17 December 2021

**SECTION 4.55(1A) MODIFICATION APPLICATION – SSD 6966
BUILDING R5, ONE SYDNEY HARBOUR, BARANGAROO SOUTH**

This modification application has been prepared by Ethos Urban on behalf of Lendlease (Millers Point) Pty Ltd (Lendlease), pursuant to section 4.55(1A) of the *Environmental Planning and Assessment Act 1979* (EP&A Act) to modify Development Consent SSD 6966 relating to Residential Building R5 at Barangaroo South (the site).

2.5 Updated Roofscape

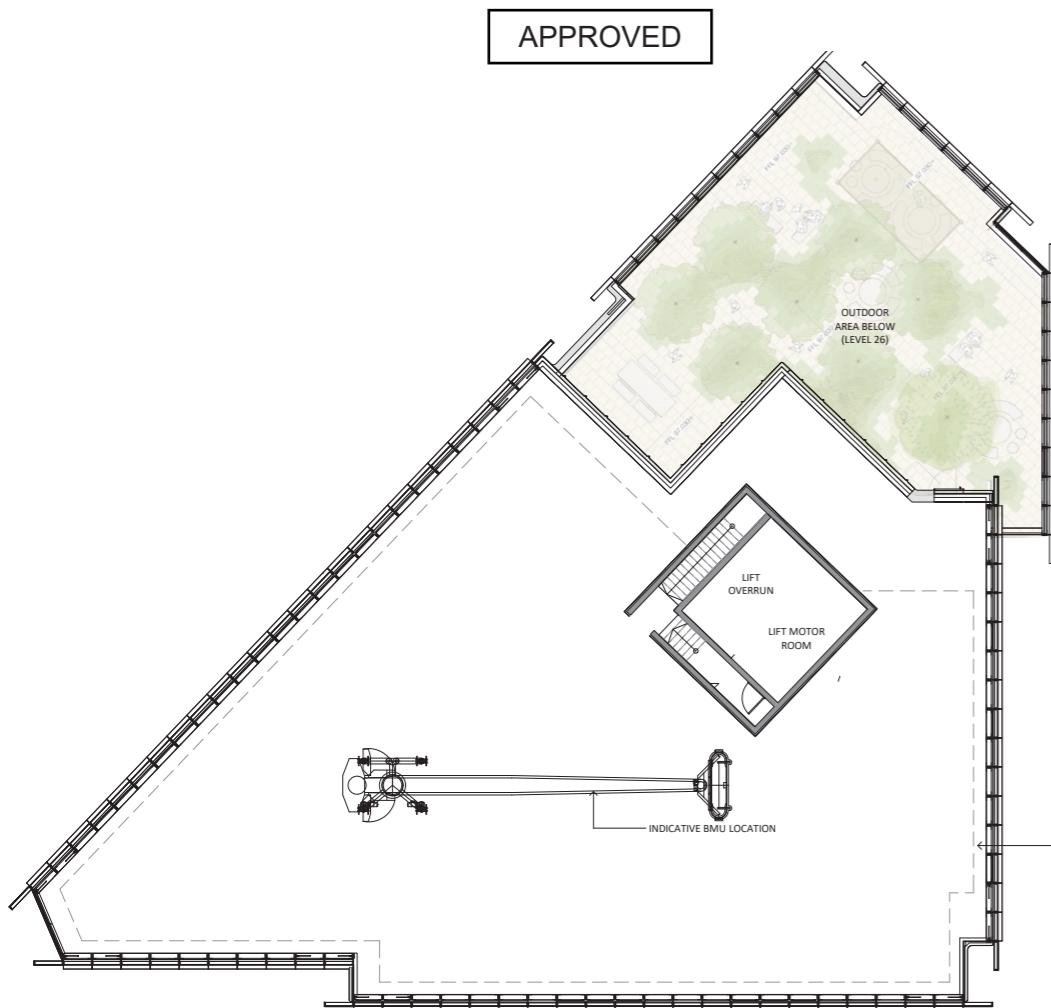
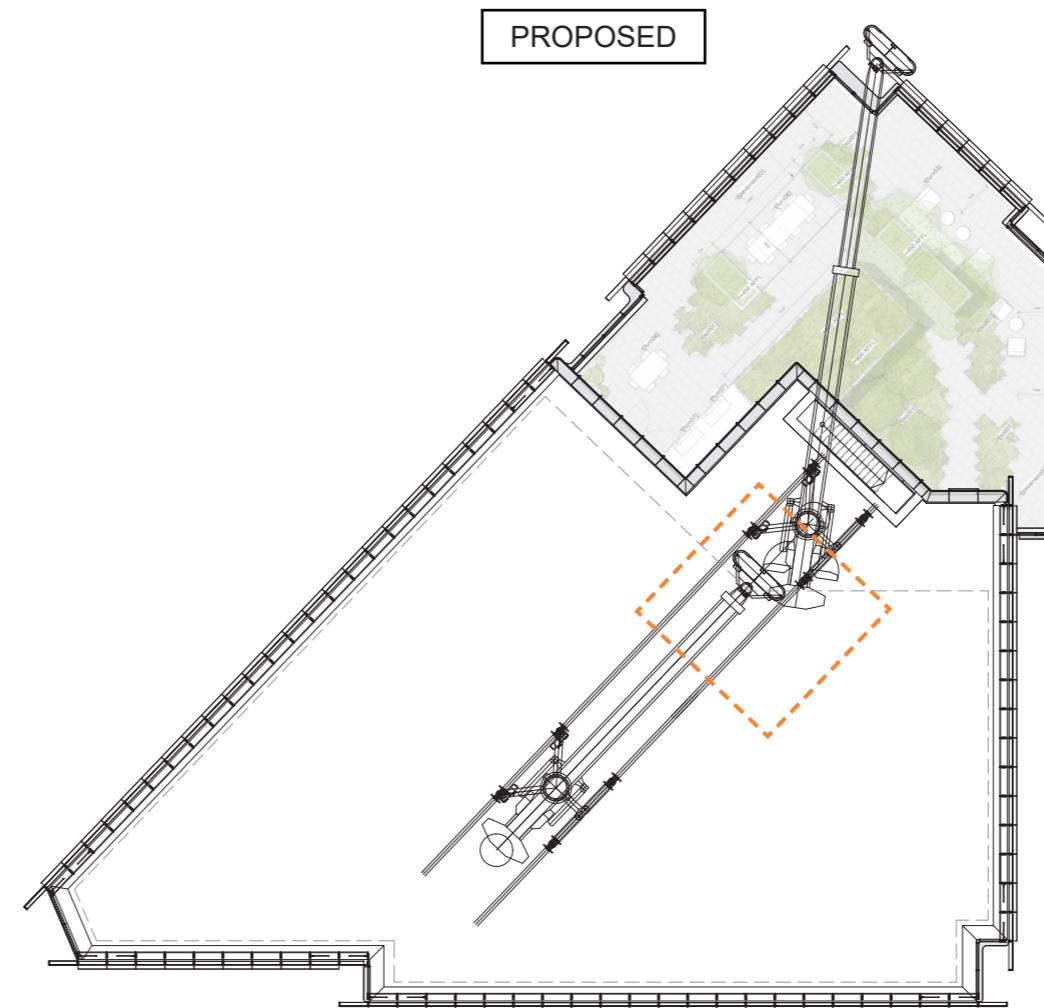
2.2.4 Reconfiguration of rooftop plant layout

Several refinements to the roof layout of the building are proposed to improve its visual impact from surrounding residential buildings. These refinements include

- Removal of the lift motor room with adoption of a new vertical transportation strategy which removes the need for a lift overrun and improves the visual appearance of the roofscape.
- The removal of the lift motor room allows for a more efficient layout of building maintenance units, improving access to the Hickson Road/Waterman Quay façade area.
- More efficient layout of photovoltaic cells, maximising the available renewable energy opportunity.

Approved GF Plan

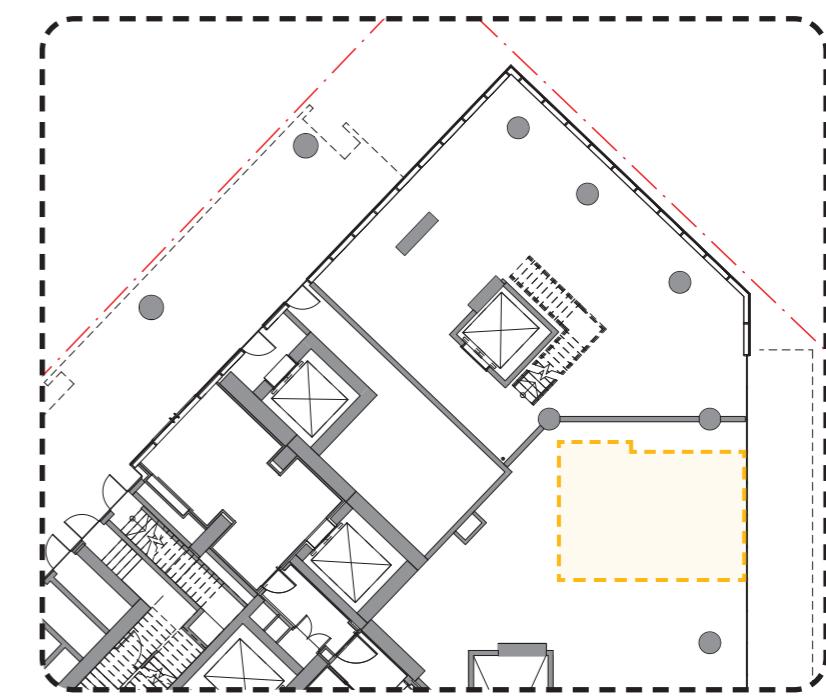
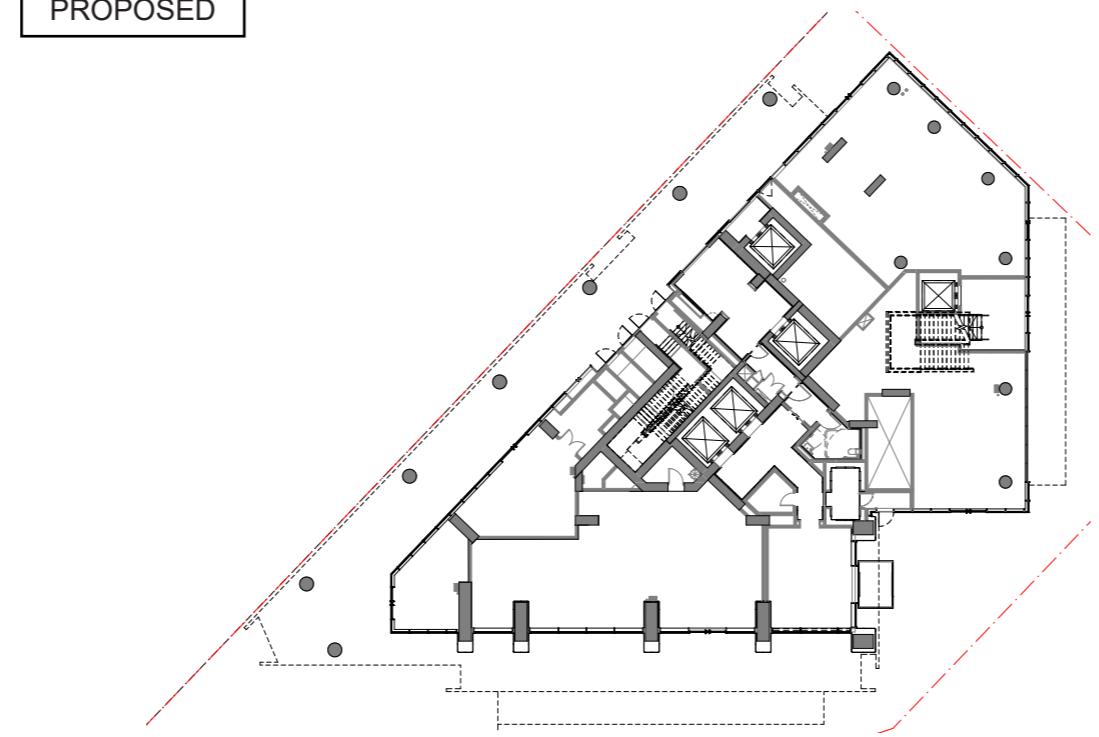
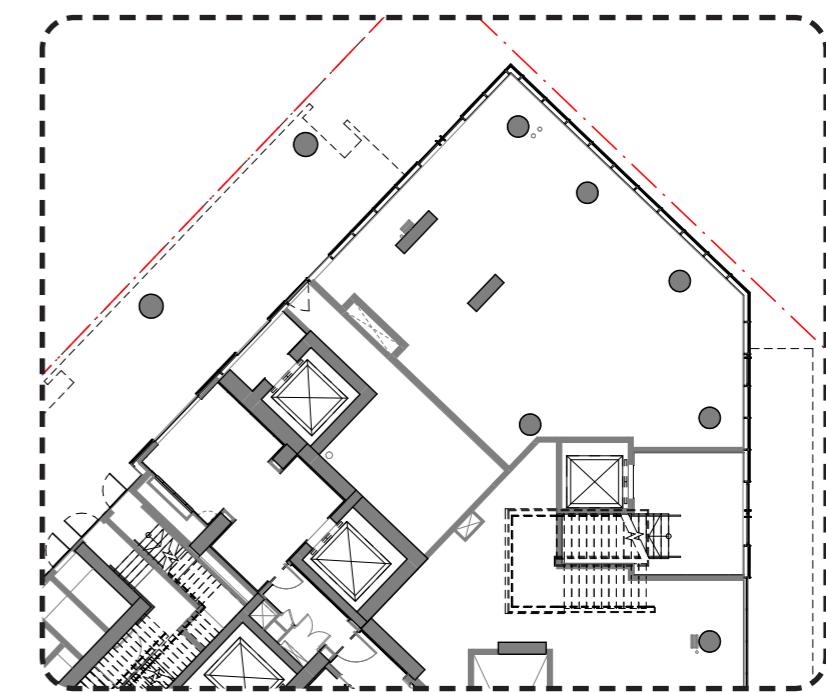
Ground Floor retail tenancy

It is proposed to amend the Ground Floor retail tenancy fronting Watermans Quay with a shift in the location of the retail stair and lift core. This change will also require a modification to Floor P1 due to the revised lift location.

As a result, refinements to the façade are also proposed including the addition of new egress doors and façade detailing adjacent to the new retail lift lobby.

3.2 L02 Facade Refinements

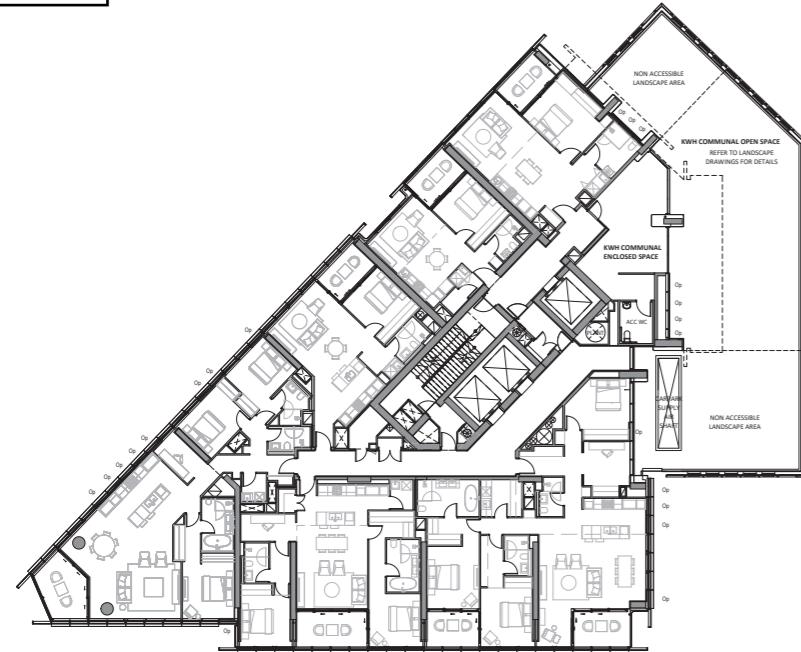
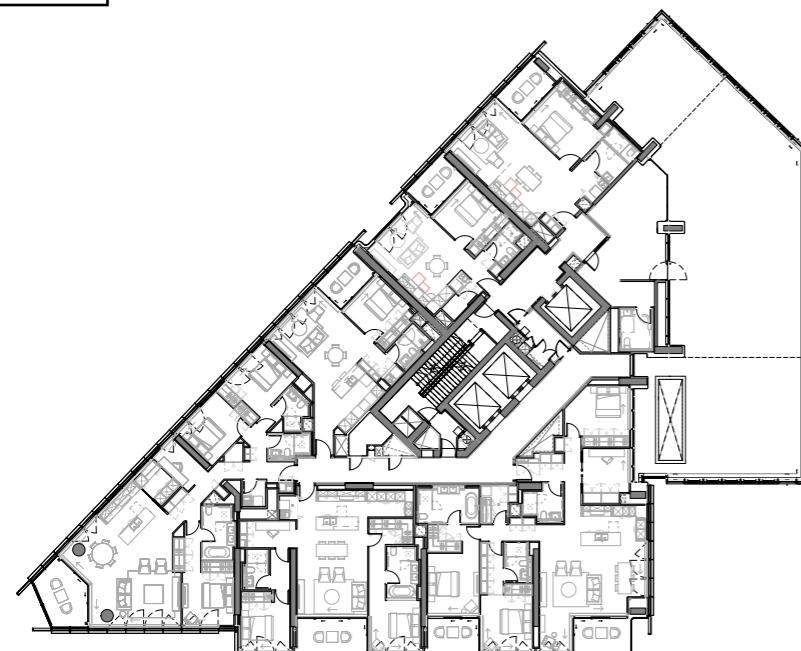
A minor amendment to the Key Worker Housing common space façade on Level 2 of the podium is proposed to provide a DDA compliant pivot door to the external terrace. This is highlighted below in **Figure 19** and **Figure 20**.

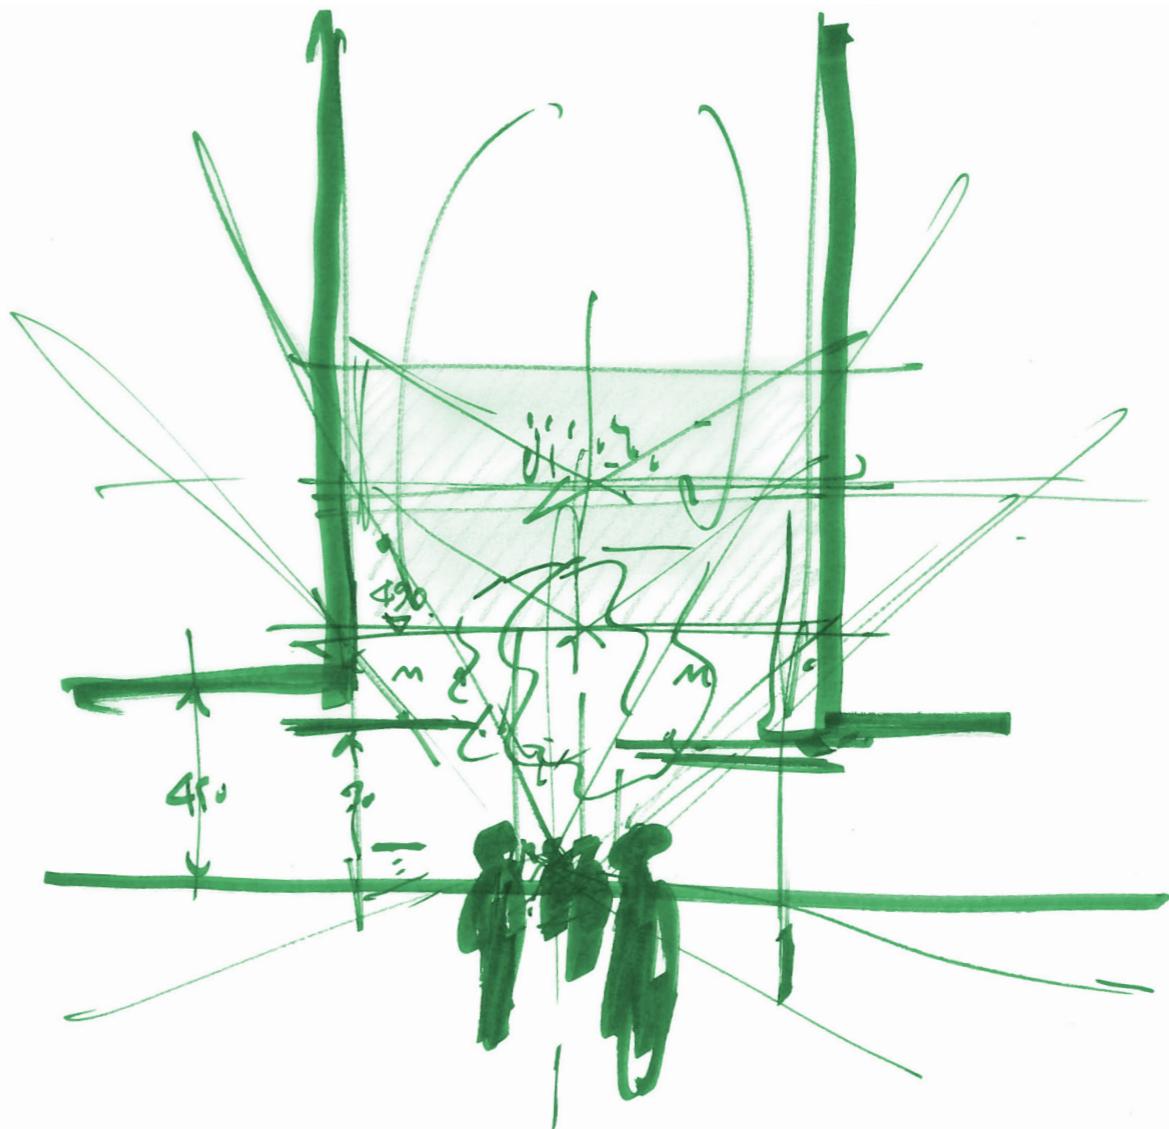
Through further detailed design development of the podium façade, as well no signage now proposed adjacent to the Ground level entrance doorways, it is proposed to revise the location of potential building identification signage zones in the following locations:

- Southwest façade entry vestibule.
- East façade entrance.

Only one zone will be used for signage, and the revisions will expand the possible final location of such.

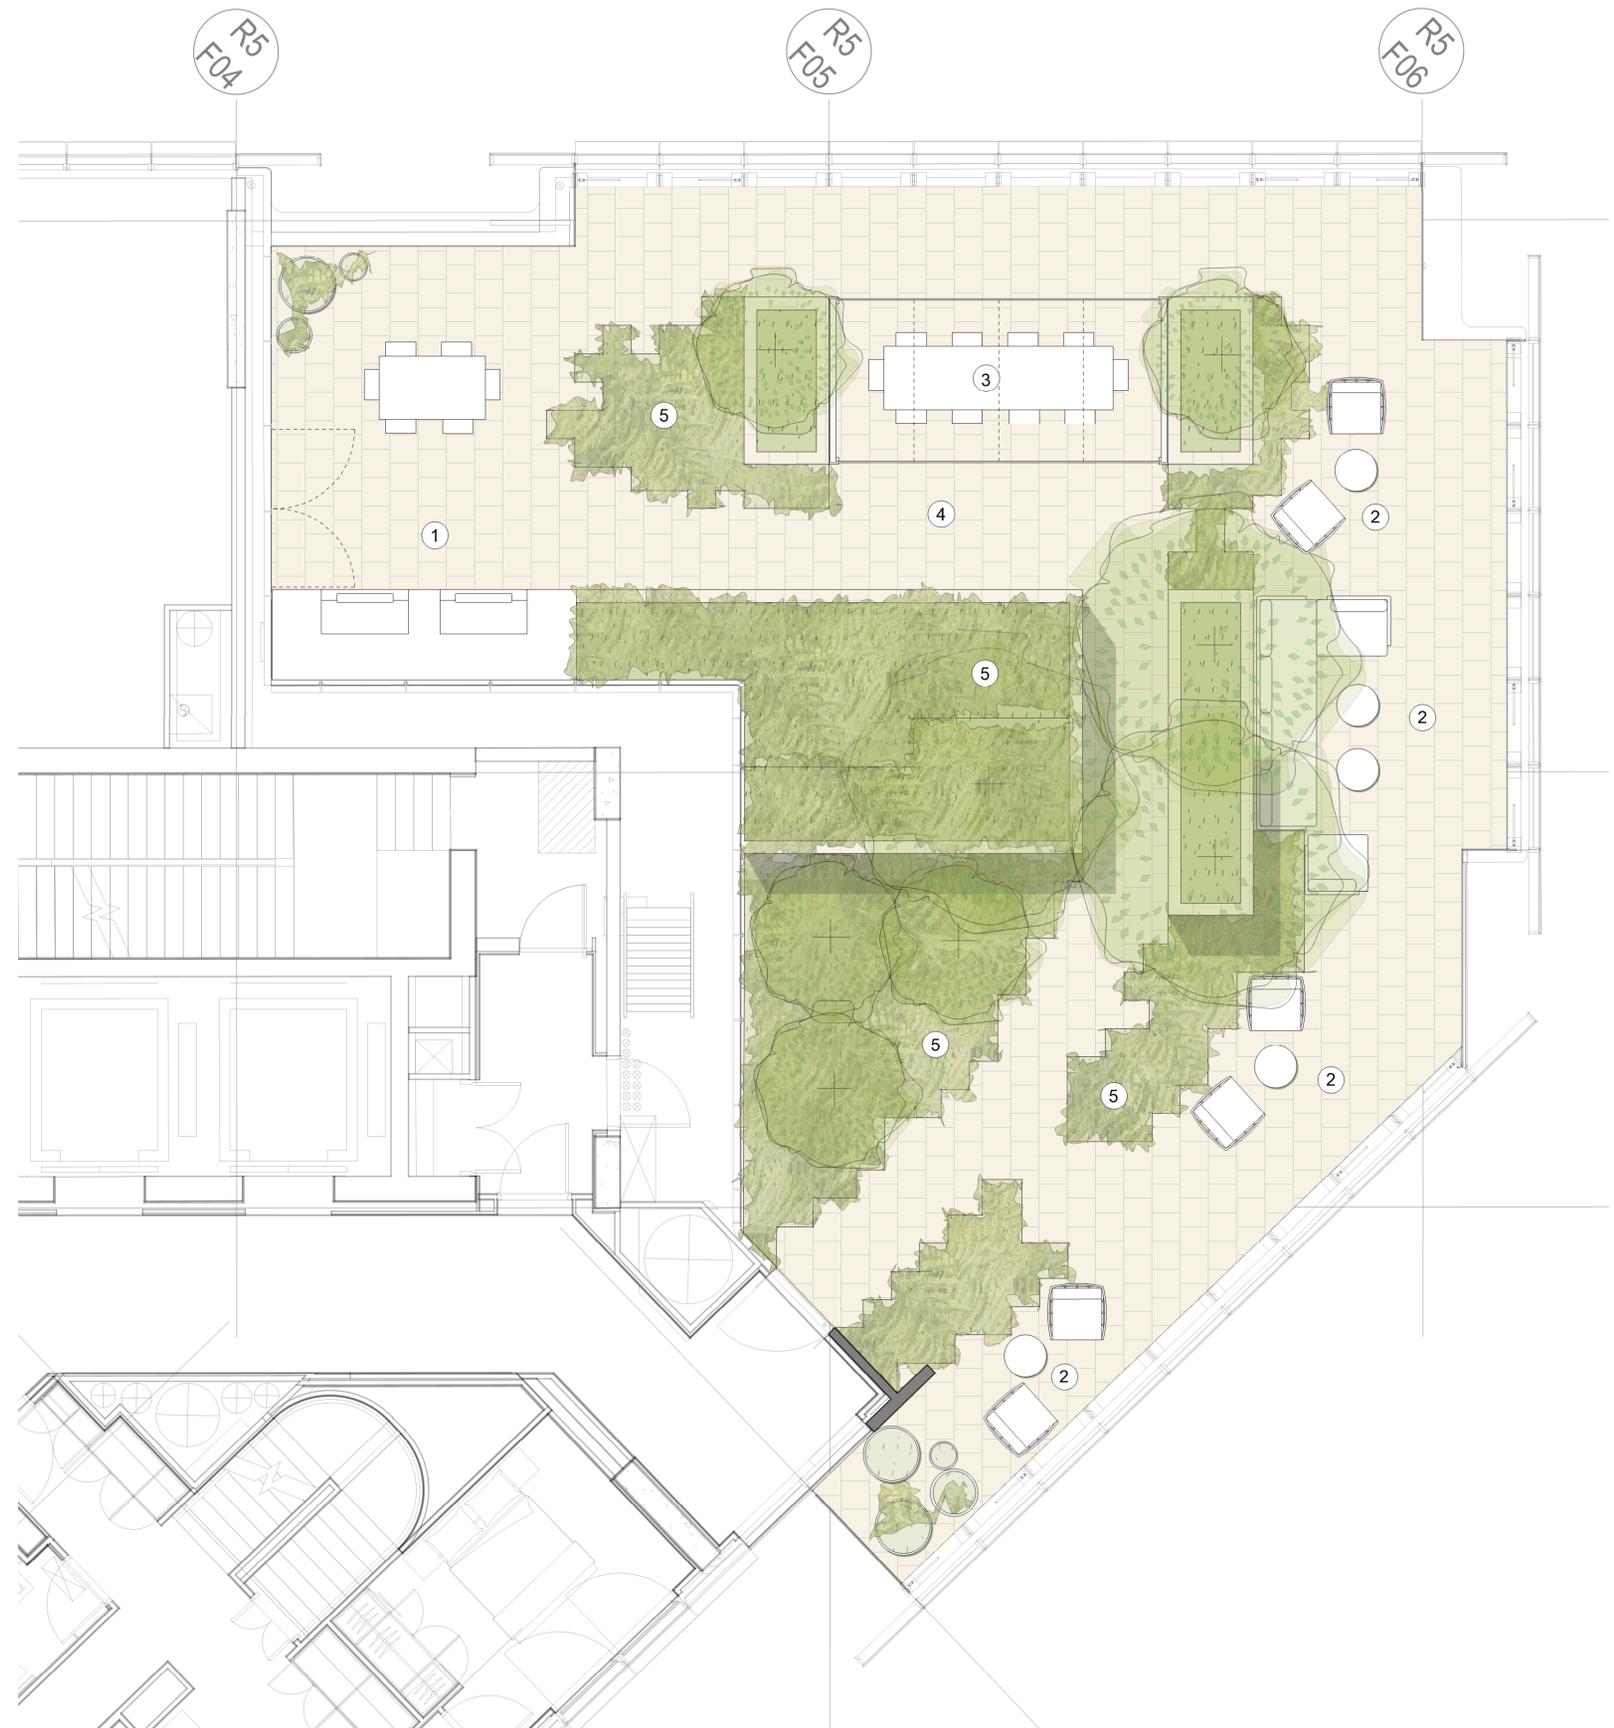
It is proposed to amend the layout of the landscaped planter boxes on the Level 31 terrace to deliver a rationalised layout that more appropriately distinguishes between the recreational spaces and responds to improving the layout of the seating areas by locating such seating closer to the façade areas, and therefore improved outlook. In addition, the small shade structure has been relocated from the southern façade area to the eastern façade area, allowing covered seating in a location with more desirable views, which will enhance the useability of the outdoor area. The proposed layout provides more accessible paths of travel to the seating and BBQ areas. The proposed amendments to the terrace are identified below in **Figure 13** and **Figure 14**.
